**KIRKLEES METROPOLITAN COUNCIL
INVESTMENT & REGENERATION SERVICE**

Reference No: 2020/62/92782/W

Site Address: Huddersfield Lawn Tennis and Squash Club,
Cemetery Road, Edgerton, Huddersfield, HD1 5NF

Description: Erection of canopy to Padel courts

Proposed end elevation (1:100)

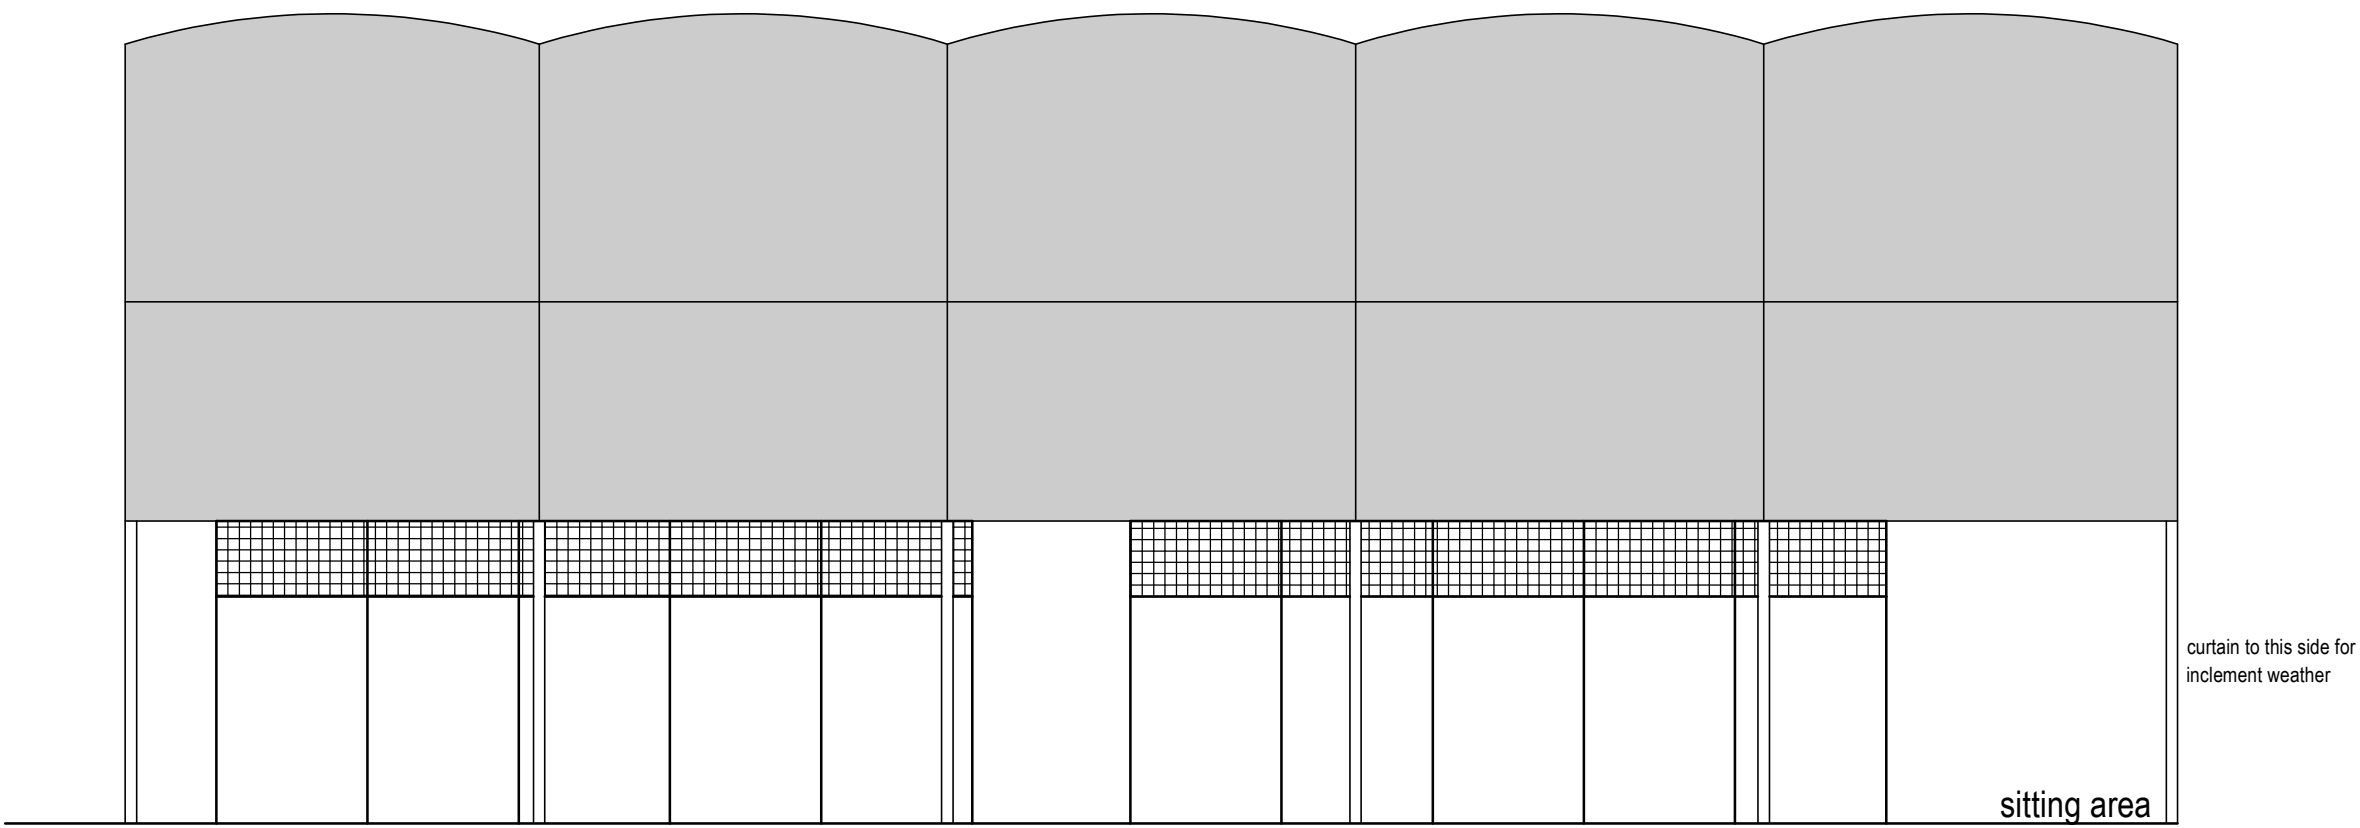
Justification was requested by officers for the proposed height of the canopy roof. The applicant's agent provided further detail relating this matter by e-mail on 9th October 2020 to address this issue. In addition, the applicant's agent agreed to a condition restricting the hours of use of the padel courts on 11th November 2020.

As noted by the Council's Conservation Officer, Paragraph 194 of the NPPF states any harm to, or loss of, the significance of a designated heritage assets should require clear and convincing justification. The Council's Conservation Officer has noted that there should be clear and convincing justification that the height of the proposed canopy is the minimum necessary.

On this matter, the applicant's agent was asked to provide further justification for the height of the building. The applicant's agent provided a booklet from the Lawn Tennis Association (who are the governing body for Padel Tennis) which specifies court dimensions. This document states that the recommended height for new build facilities is 8 metres. As the roof of the building is curved, parts of the roof would fall below this height. It is noted by the applicant's agent that the parts of the curved roof are above 8 metres height to allow for 'lob shots' which are noted as a common shot in the sport and officers see no reason to disagree with this. In addition, the roof would be a similar height to that on the existing indoor tennis building on the site. Officers are content with the justification provided for the height of the building.

The proposed building would be relatively high, being a maximum height of 10.7 metres and would be somewhat functional in its appearance. That said, despite its overall height, views would mainly be restricted to Cemetery Road, Edgerton Cemetery and New North Road given the topography of the area and existing built development in the area.

3. Padel courts 1 and 2 as displayed on Drawing No.2020 20 02A shall not be used outside the hours of 07:30 to 22.30 on Monday-Sunday (including Bank Holidays), unless otherwise agreed in writing by the Local Planning Authority. The floodlighting serving Padel courts 1 and 2 shall only be used when those courts are in use.
